Addendum No. 1

RE: Contract # C203649

Onslow County (U-4906)

SR-1308 (GUM BRANCH RD) FROM WEST OF SR-1313 (MILLS FIELDS ROAD)
TO EAST OF SR-1324 (RAMSEY ROAD)

PROJECT REFERENCE NO. U-4906		SHEET NO. 7
RW SHEET NO.		
ROADWAY DESIGN ENGINEER	HYDRAULICS ENGINEER	
DOCUMENT NOT CONSIDERED FINAL UNLESS ALL SIGNATURES COMPLETED

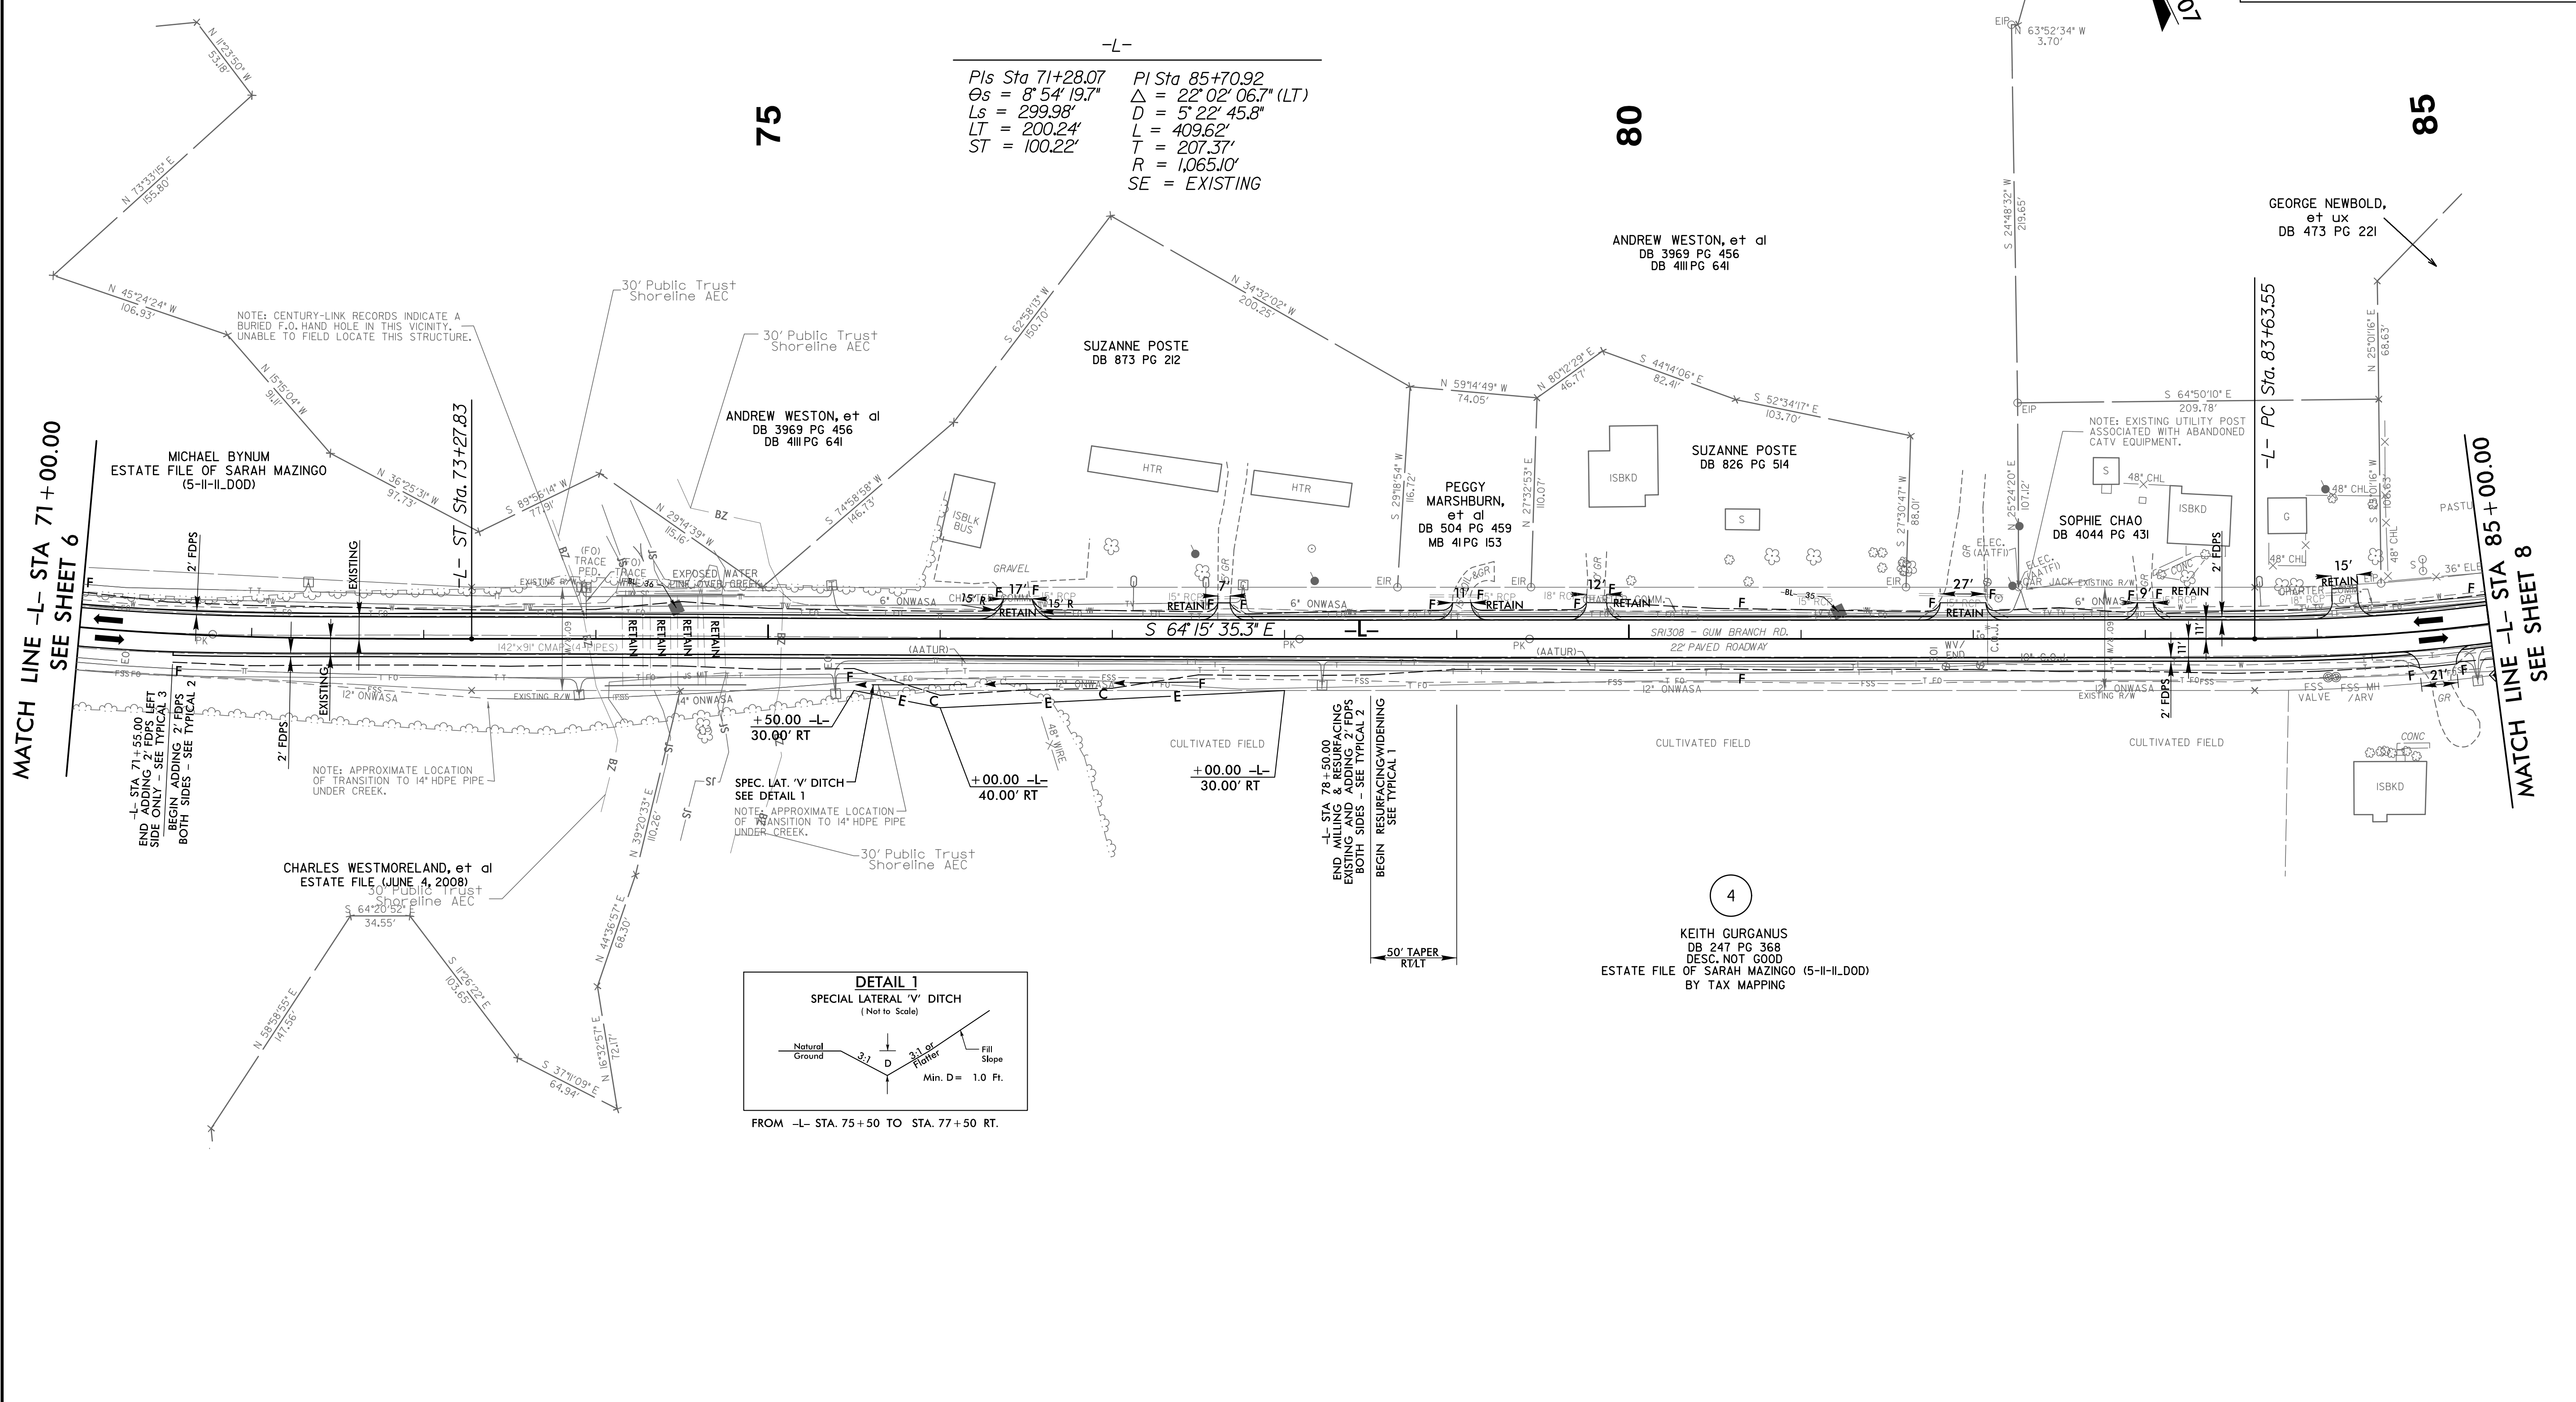
Sheet No.	Revision
1A	1C thru 1C-2 removed from Index of Sheets. RW01 thru RW26 added to Index of Sheets.
(Removed) 1C thru 1C-2	Location and Surveys updated project information to create new RW sheets and to remove the old 1C sheets.
(New) RW01 thru RW26	Location and Surveys updated project information to create new RW sheets and to remove the old 1C sheets.
7, 23, 26	Updated plans sheets due to a revision to the buffer zones.
TMP-1, TMP-1A, TMP-1B, TMP-3, TMP-9	Updated Traffic Control sheets for lane shift and the addition of portable concrete barrier while a water main is being replaced at the end of the project.
(New) TMP-1C, TMP-9A	New Traffic Control sheets for lane shift and the addition of portable concrete barrier while a water main is being replaced at the end of the project.
